CITY OF PORTLAND, MAINE

February 3rd, 2014

Project Name: "118 on Munjoy Hill" Condominium
12 unit residential, and 2 unit commercial, condominium
Project ID: #2013-255
Project Address: 118 Congress Street
CBL: 16-D-2
Applicant: Ed Theriault, EMT, LLC (118 Condominiums, LLC)
Planner: Jean Fraser

On January 28th, 2014 the Portland Planning Board considered and approved a Level III Final Site Plan and Subdivision proposal for the construction of a 4-story 14 unit condominium building at 118 Congress Street, comprising 2 commercial units totaling approximately 1800sq ft floor area, 18 parking spaces on the ground floor to the rear of the commercial units, and 12 residential units above.

LANDSCAPE PLAN
SCALE: 1" = 8'-0"

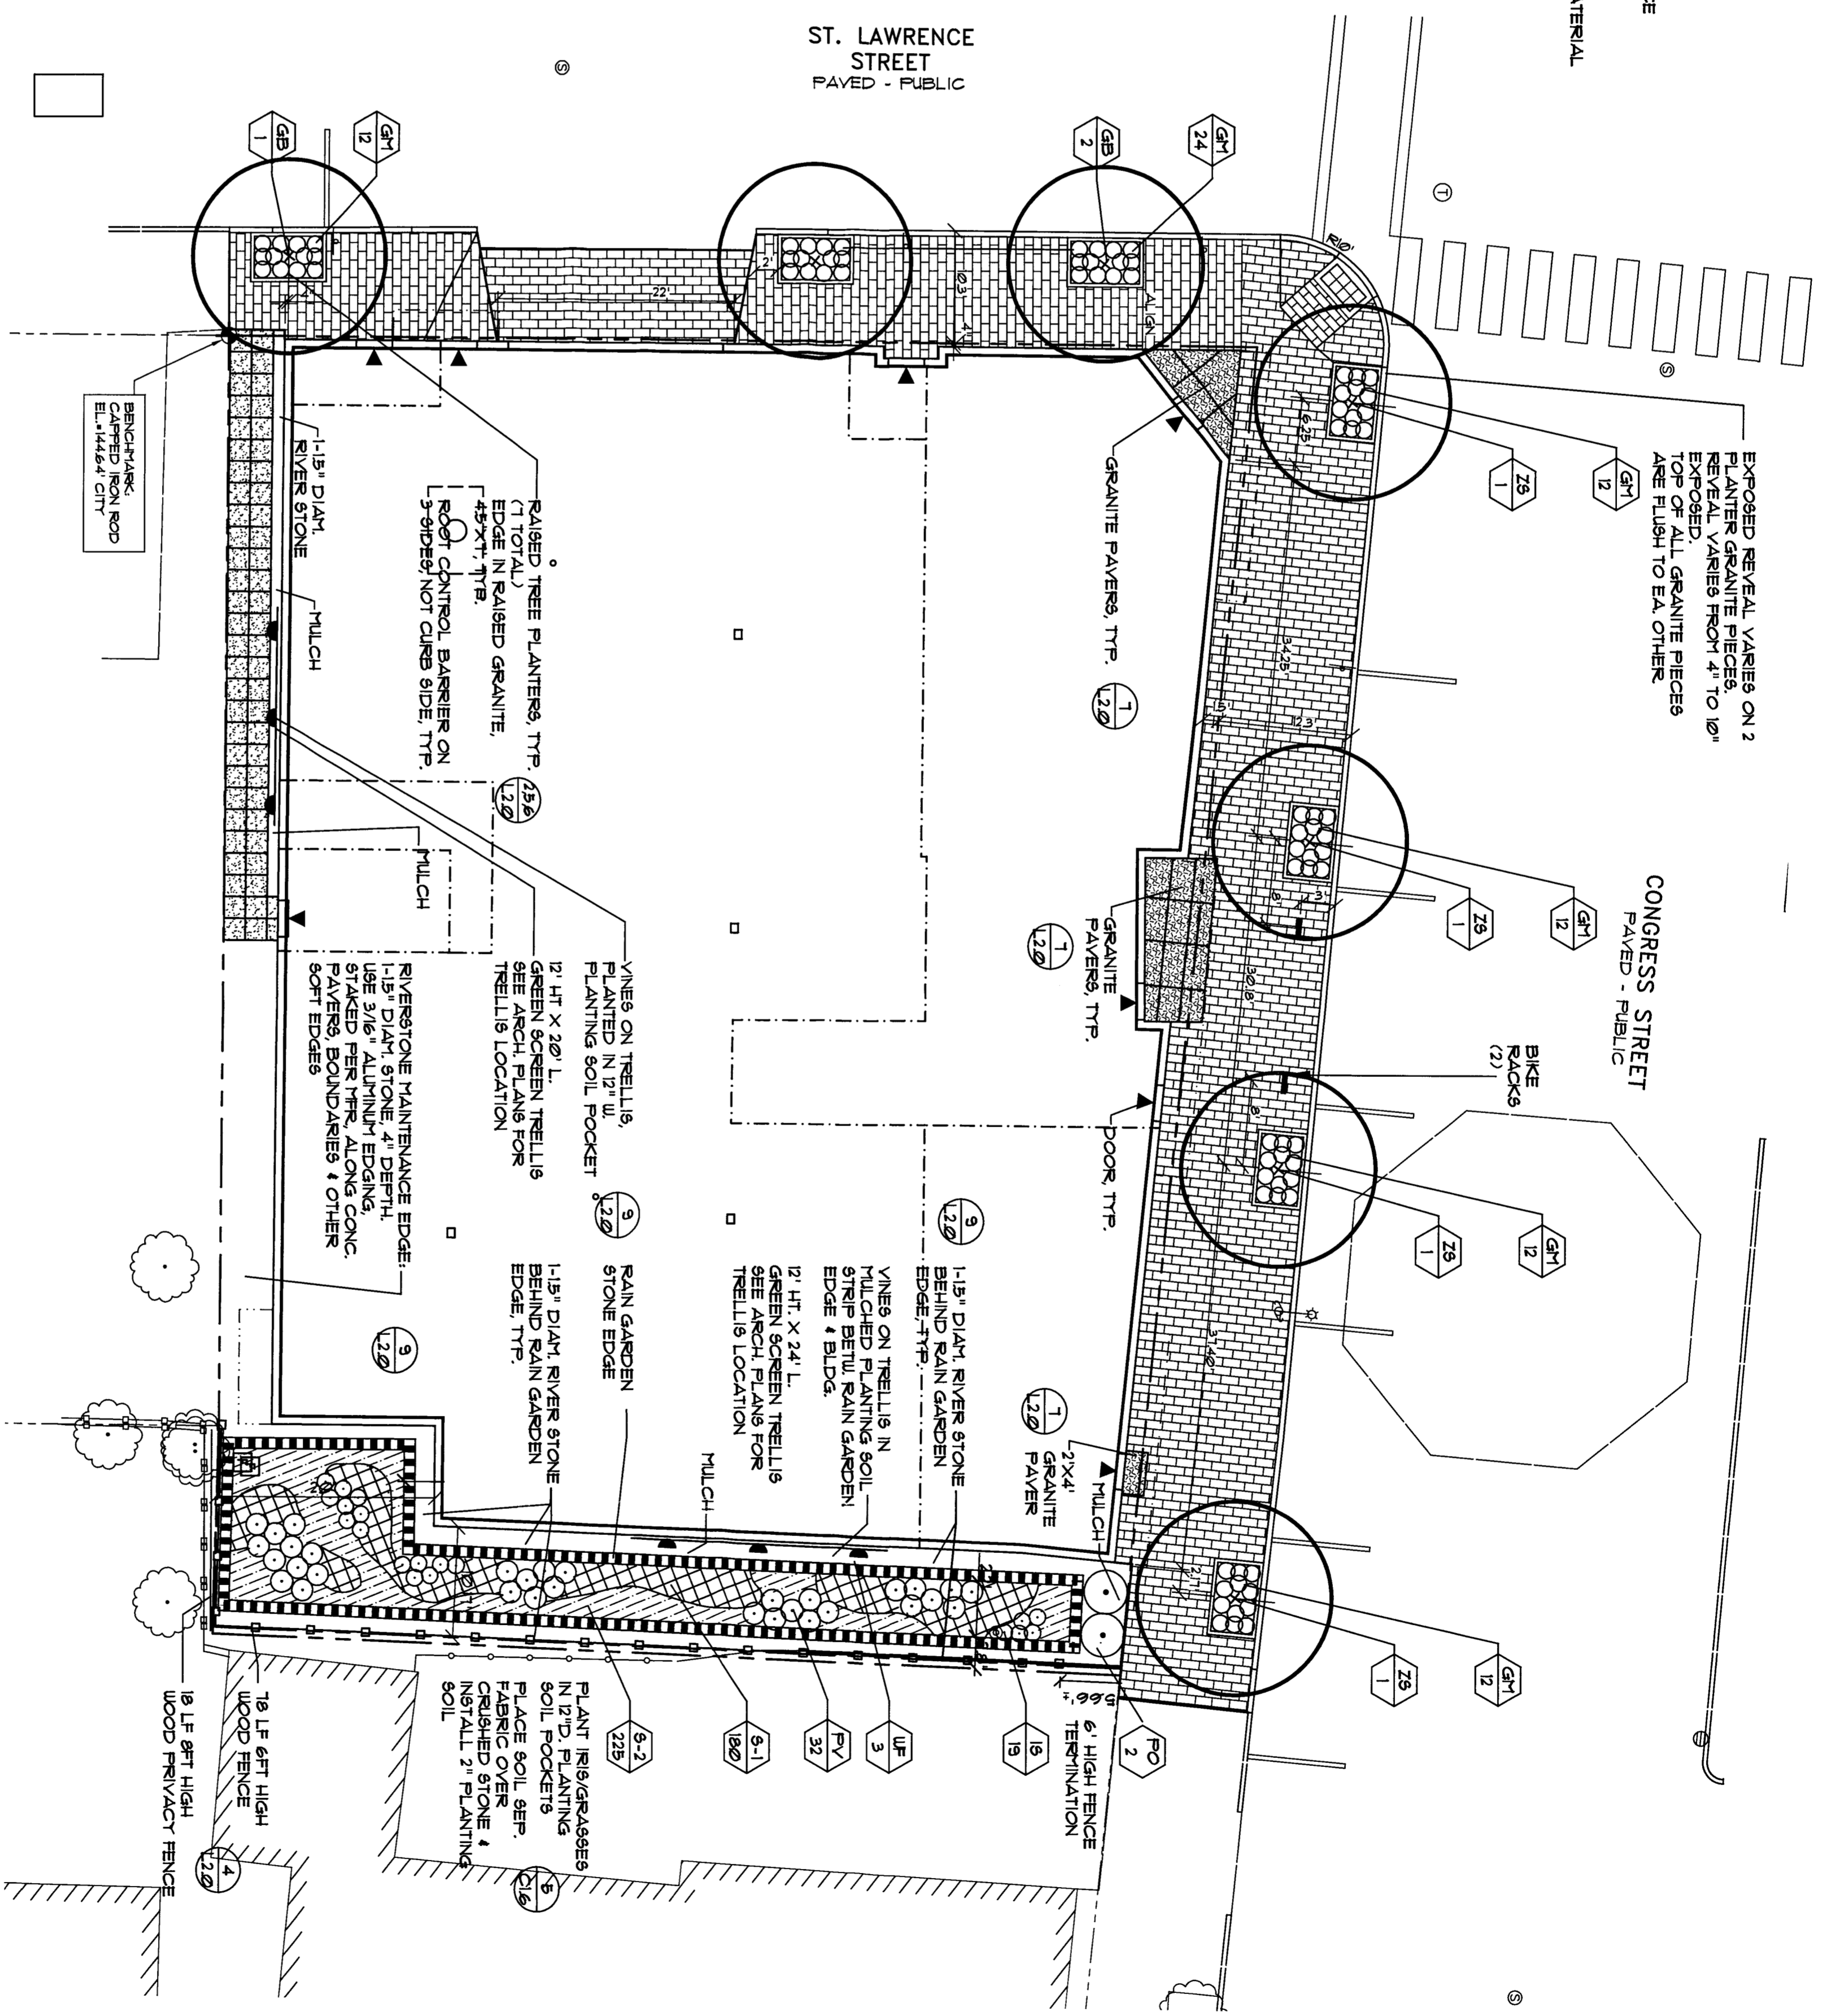
a) Street-trees - the project proposes to plant (6) street trees, (4) along Congress Street, 'save' the existing Pin Oak and plant (2) new on Saint Lawrence Street. Updated plan shows the trees planted in raised granite tree wells with herbaceous planting. If on-street parking is proposed, the tree spacing or setback away from the curb to prevent the opening of car doors is important. The trees can be placed to match the in-between on-street parking, making sure there is good access to the sidewalk from parked cars. The residential tree standard of one tree per unit would also be a condition. Building overhangs over the public way should be discouraged to allow the street tree growth.

'Tree Save' - I was hoping the project could protect or save the large Pin Oak on Saint Lawrence Street, while the recent plan does show this, a recent site visit confirmed the crown of the tree would be severely impacted or one-sided, thus reluctantly yield to the fate of removal due to proposed building location. An additional street tree would be requested. Also, the proposed new tree on Congress Street near the corner of Saint Lawrence should be shifted slightly away from the intersection perhaps 2 - 3'. The recently planted American Elm along Congress Street should be saved and replanted by the city.

Tree types - It would be ideal if the tree types along Congress Street are all the same species. I would recommend the Columnar 'Musashino' Zelkova to be ideal due to the narrow space. See <http://www.jfschmidt.com/articles/musashino> and photo below.

The 'Red Sunset' Maple crown shape is too broad for this space. Along Saint Lawrence Street again a more narrow tree is needed, it could be Ginkgo 'Magyar' or 'Autumn Gold' cultivar (seedless), due to narrow sidewalk space. (photo 'Musashino' Zelkova, narrow vase shape crown)

b) Landscape - The recent revision adds herbaceous planting to the tree planters and the 'backyard' / rain-garden edge. Additional screening to the adjacent property should be considered, this might be achieved by adding higher branching landscape planting or higher fencing (5'). The rain-garden planting with mostly herbaceous plant material will reach a low height. It does not appear to meet the B-1 Zone landscape standard (i) " A densely planted buffer and / or fencing will be required to protect neighboring properties..." Suggestions could including some taller shrub plants along with a higher wooden fence. The Green Wall proposed will also help screen the building. Additional green-wall / landscape planting could be used on the West elevation to the left of the garage door, this area seems blank; and to the left of the center door on Congress Street away from the overhead canopy.

- vi. That the applicant shall submit a revised Landscape Improvement Plan to address the City Arborist comments of 1.22.2014 in respect of the site landscape (buffering and additional trellis), to also address CPTED principles as relevant, for review and approval by the Planning Authority and City Arborist prior to the issuance of a building permit; and

1 NORTH ELEVATION
1/8" = 1'-0"

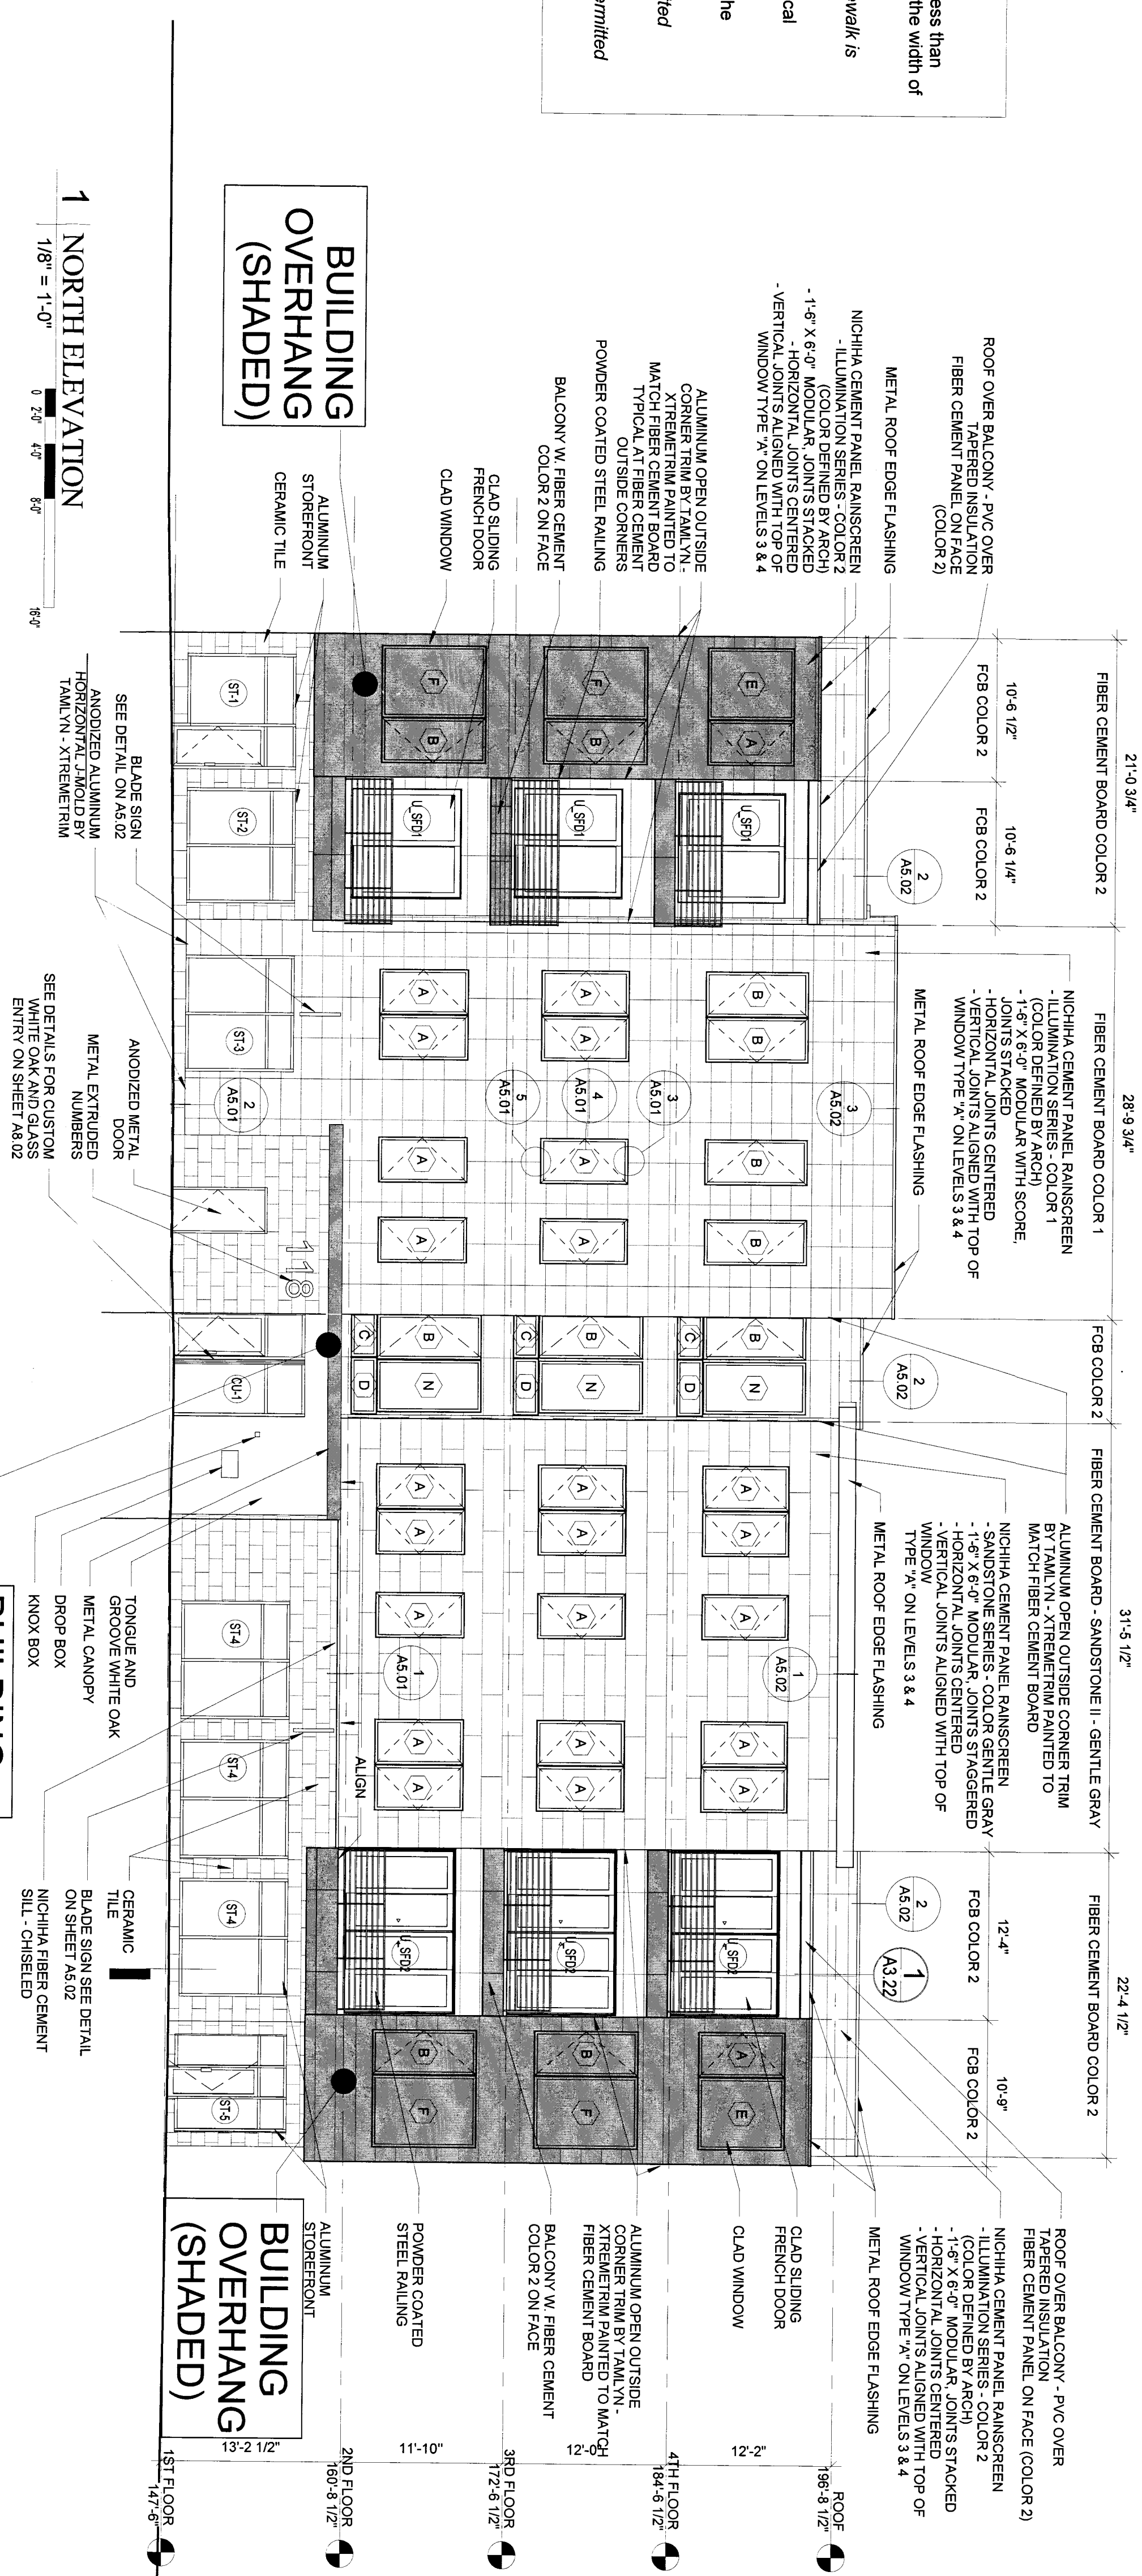
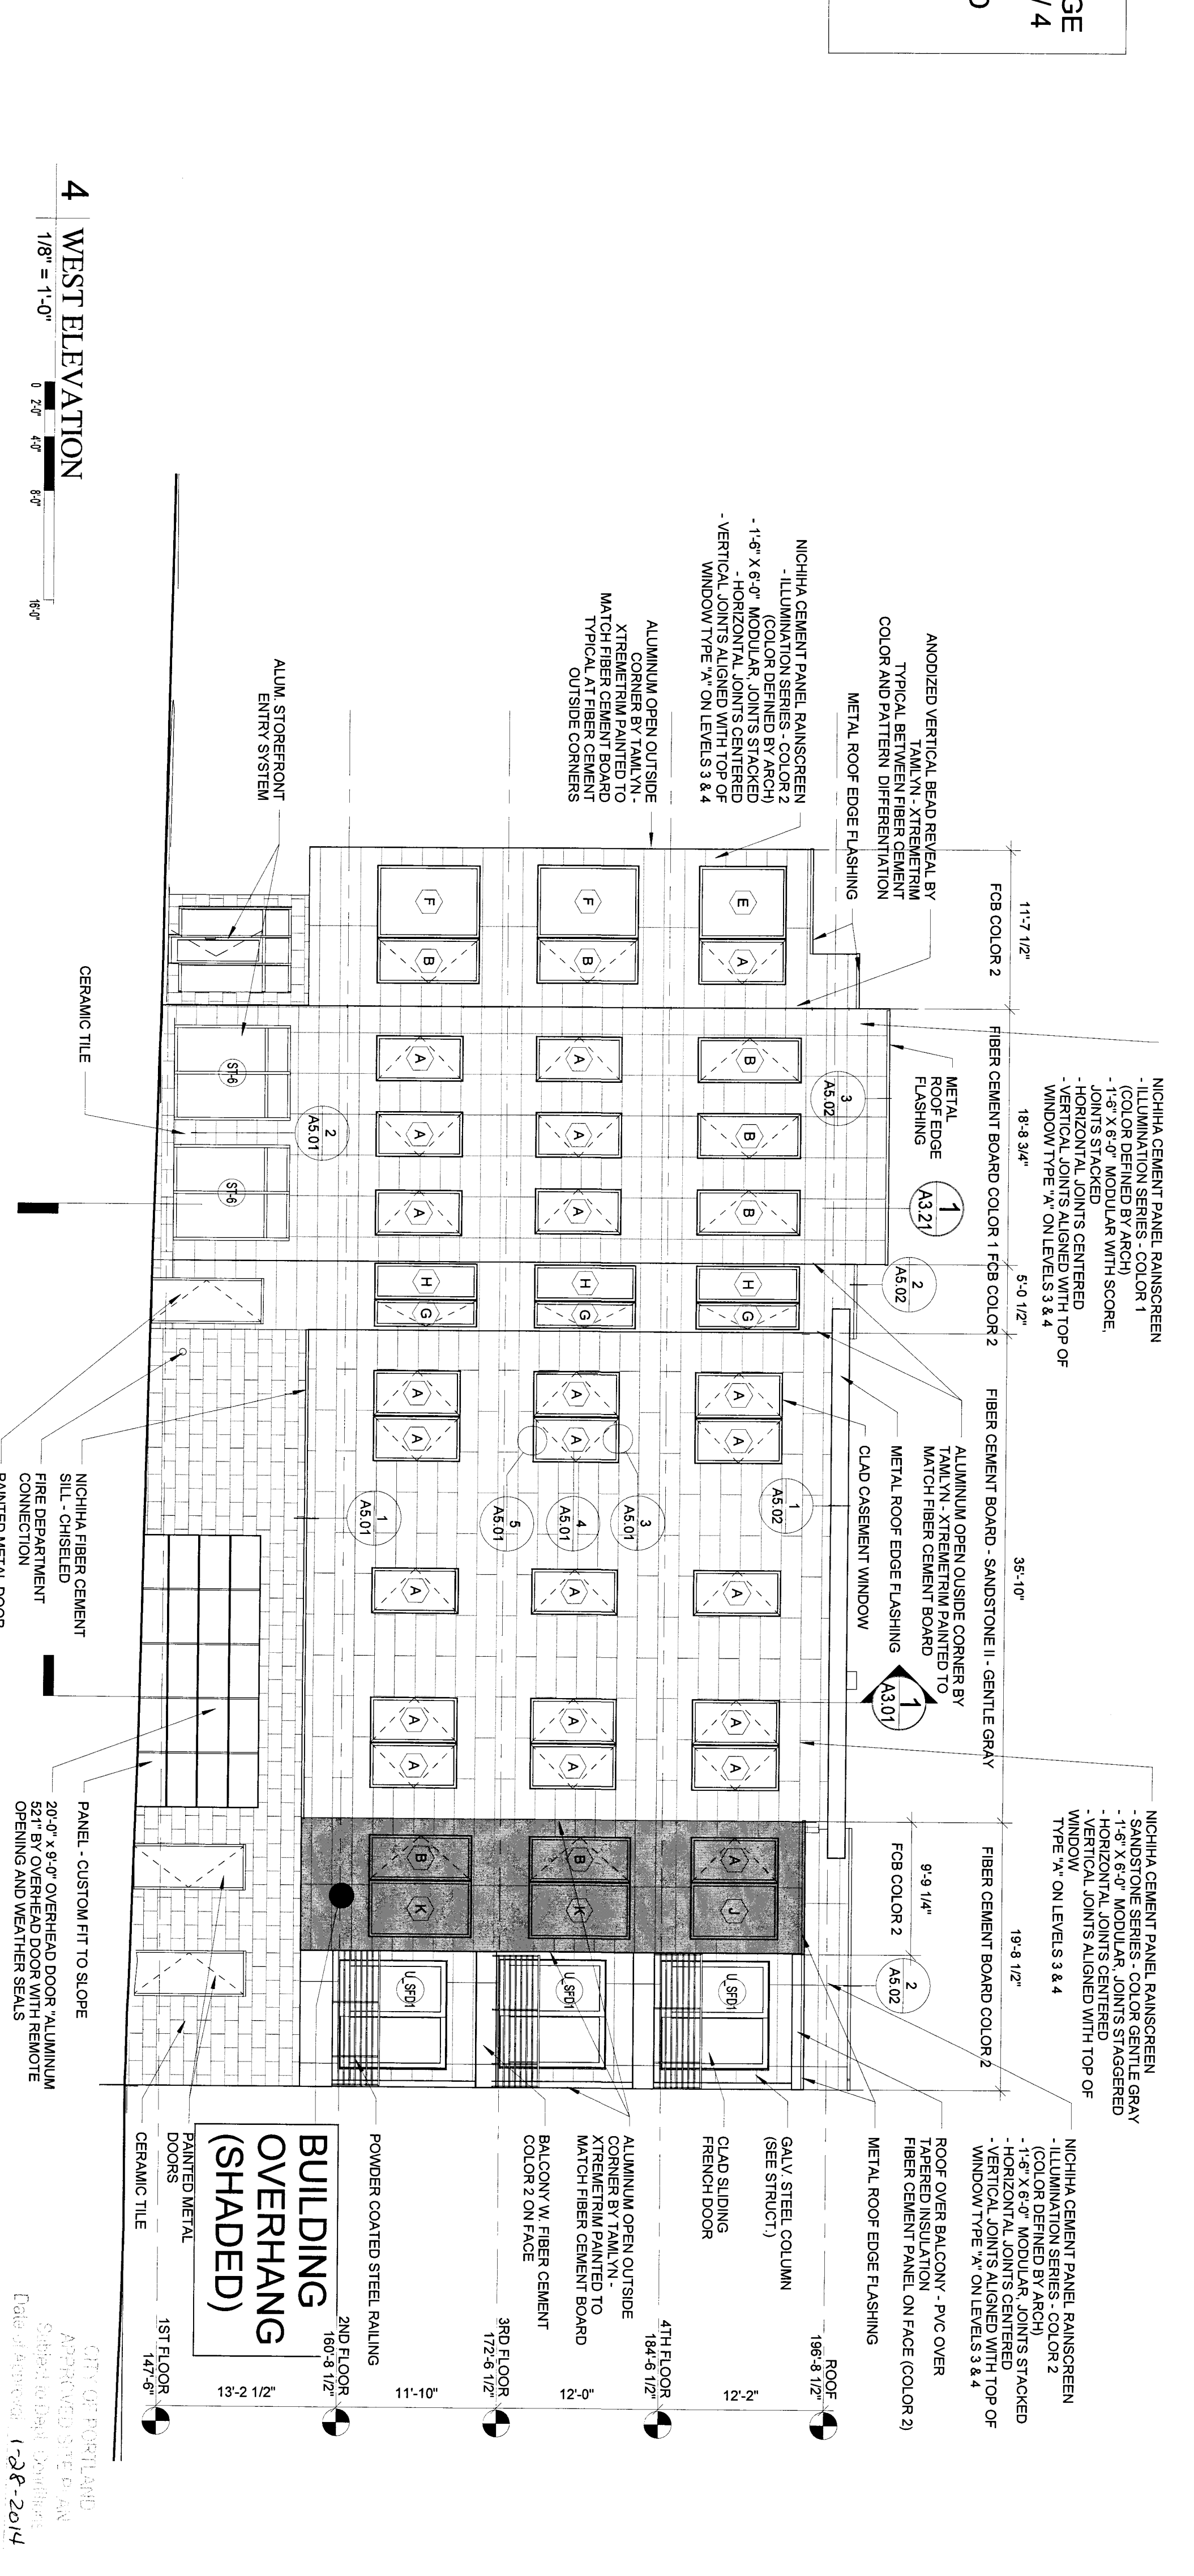
The Planning Board, in considering this project, were aware that the associated building projections (including decks) over the ROW would need a license to be approved by the City Council and that there were staff concerns about this aspect of the project. The Planning Board voted 5-2 (Dean and Hall opposed) to send a Communication to the City Council outlining the basis of the Board's support for the projections on this particular project.

- i. The applicant shall submit a revised building design that results in the decks on St Lawrence Street being within the property boundaries while maintaining the current quality of design in regards to facade articulation and variation of form, for review and approval by the Planning Authority prior to signing of the Subdivision Plat; and

- ii. That the applicant shall obtain a license from the City Council, subject to review and approval by the Corporation Counsel's office, for any building features associated with the approved design that extend over the City right-of-way, prior to the release of the signed Subdivision Plat; and
